BCA ASSESSMENT REPORT

**AUSTRAL BRICKS PLANT NO.2 EXTENSION
174-181 FERRERS RD, HORSLEY PARK**

Revision 1

Date: 17.05.2019

DRAWING TITLE
OVERALL SITE PLAN
 DATE AUG 2018 SCALE 1:2000@A3 1:1000@A1 JOB NO. 18212 DRAWING NO. DA 101A C

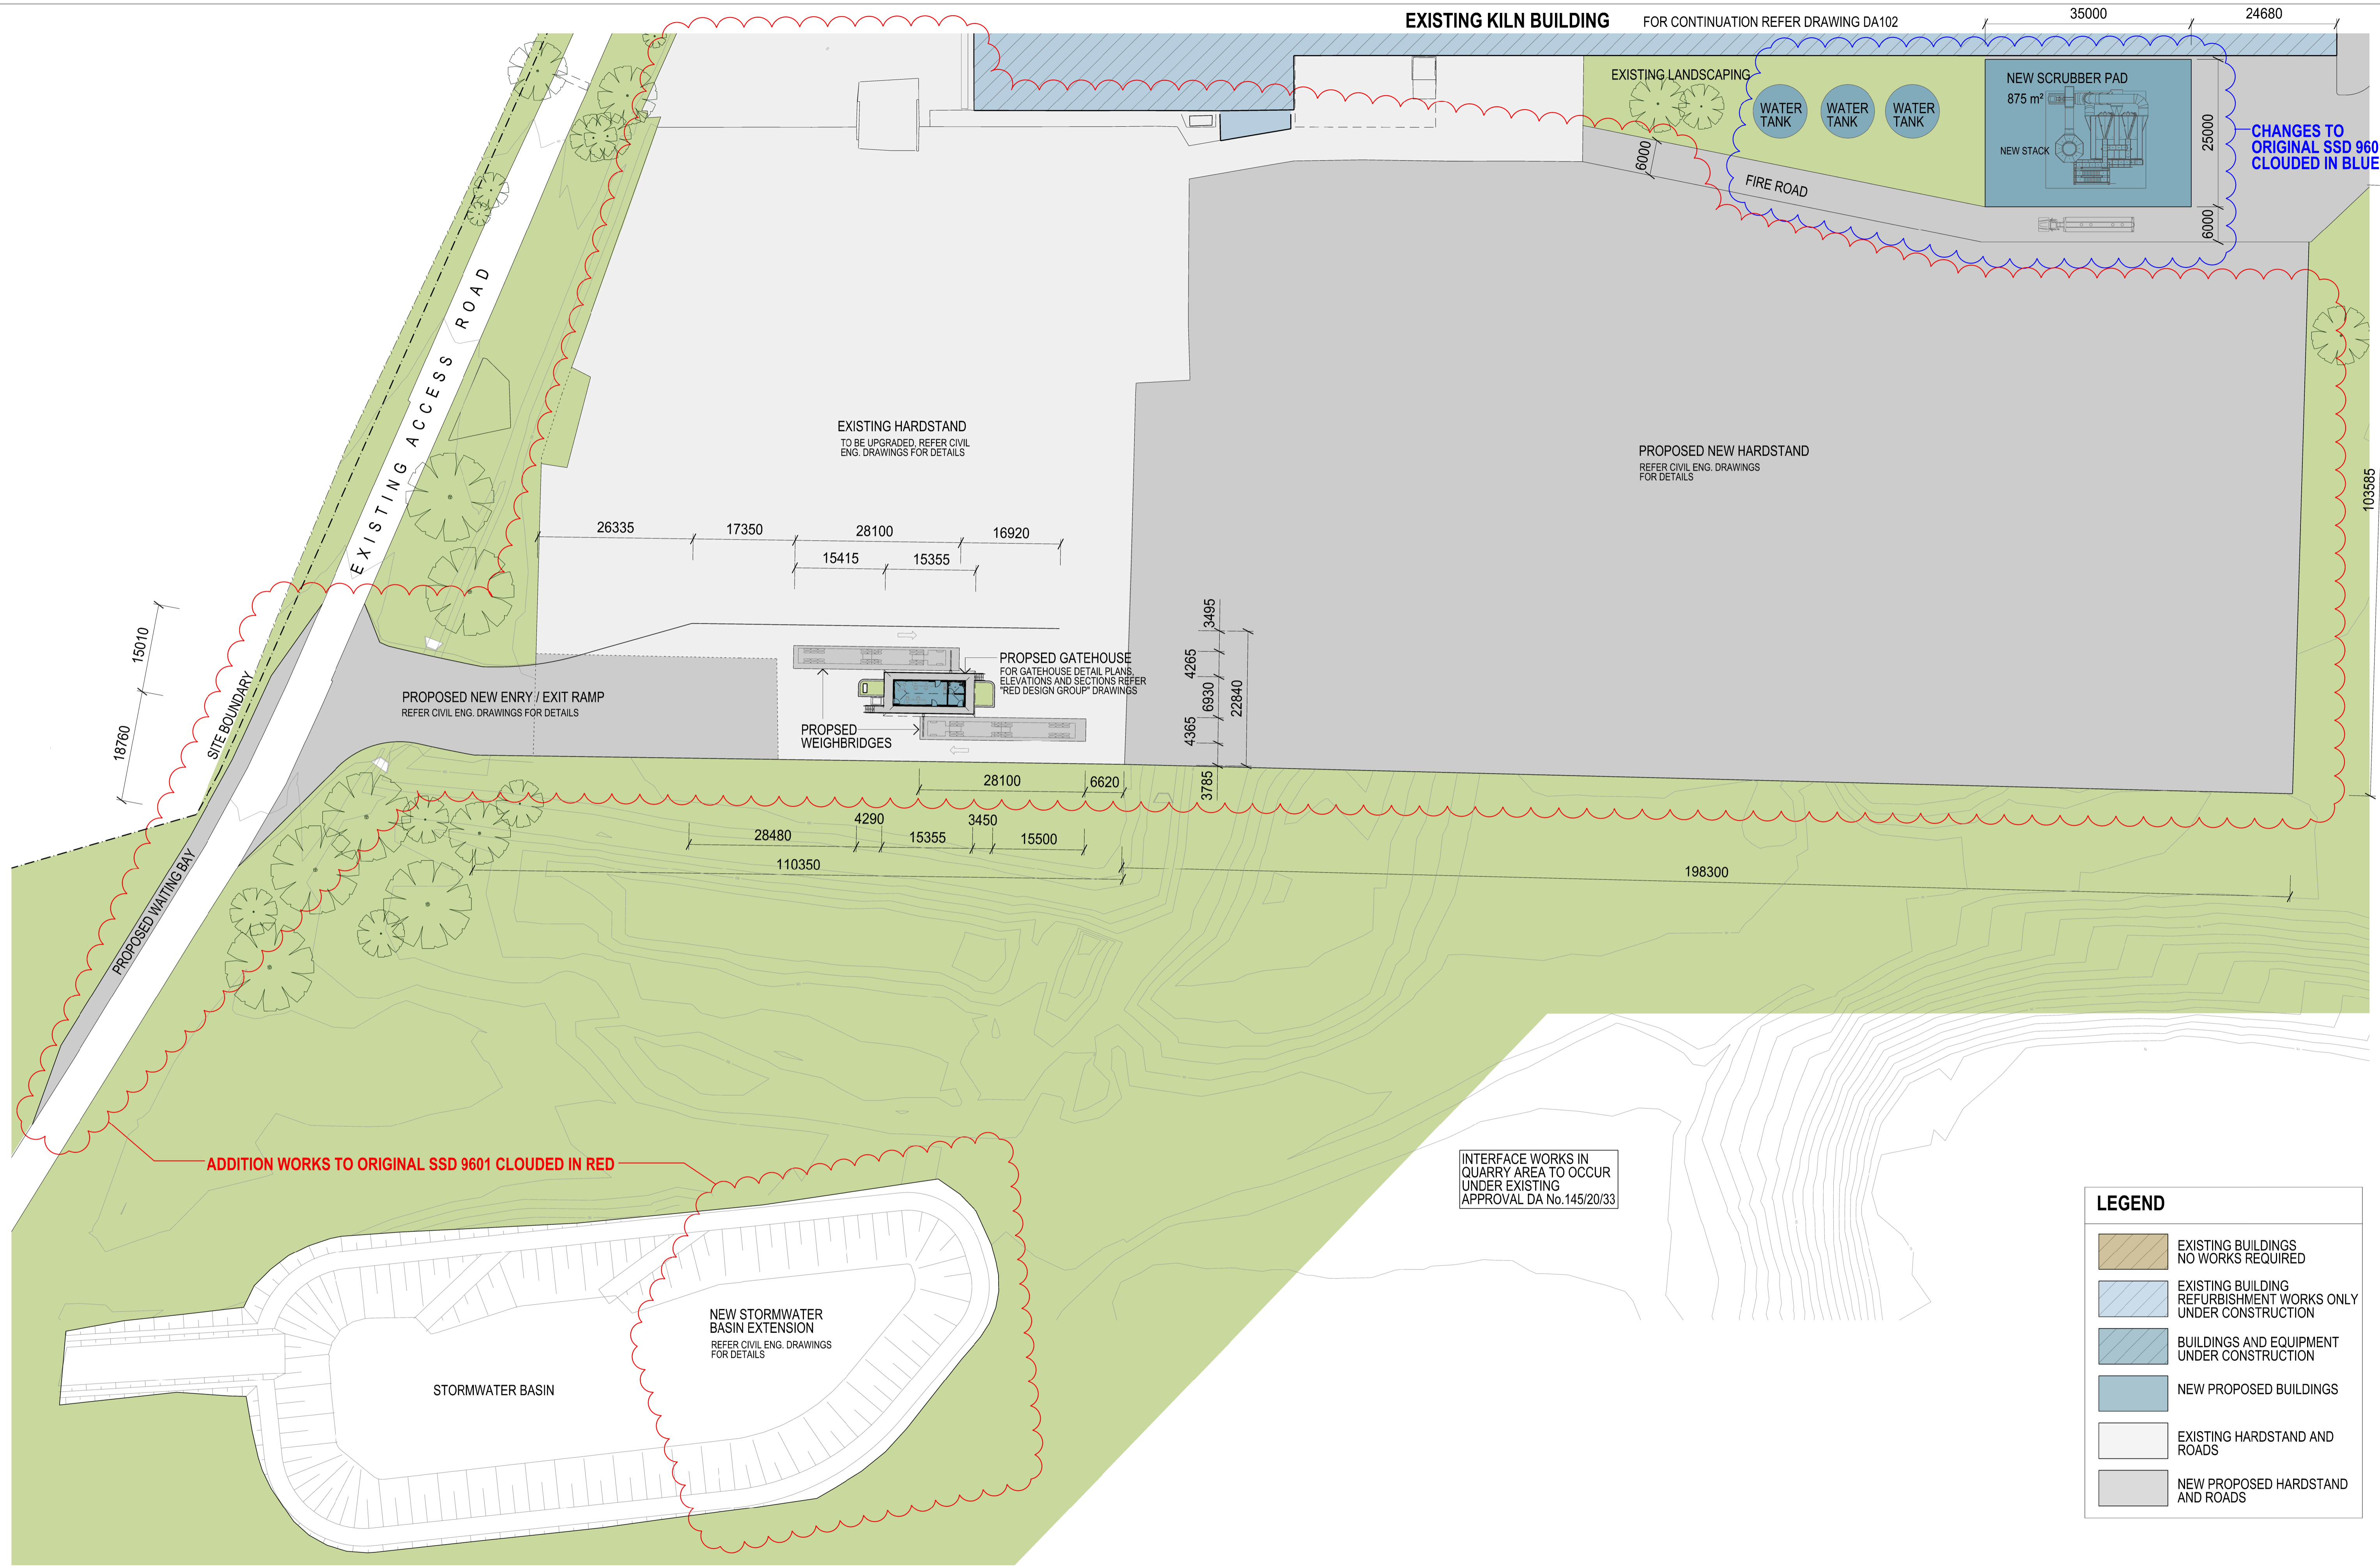
Comments: The existing building does not comply with the provisions of C2.4, however, the proposed extension and ancillary external hardstand have provided a compliant 6m wide vehicular accessway around the full perimeter of the Existing Kiln/New Production Building. Confirmation of the width of all parts of the new and existing driveways will be required at CC stage to confirm if a Performance Solution is required from the Fire Engineer for the minor non-compliances circled in red in the mark-up below.
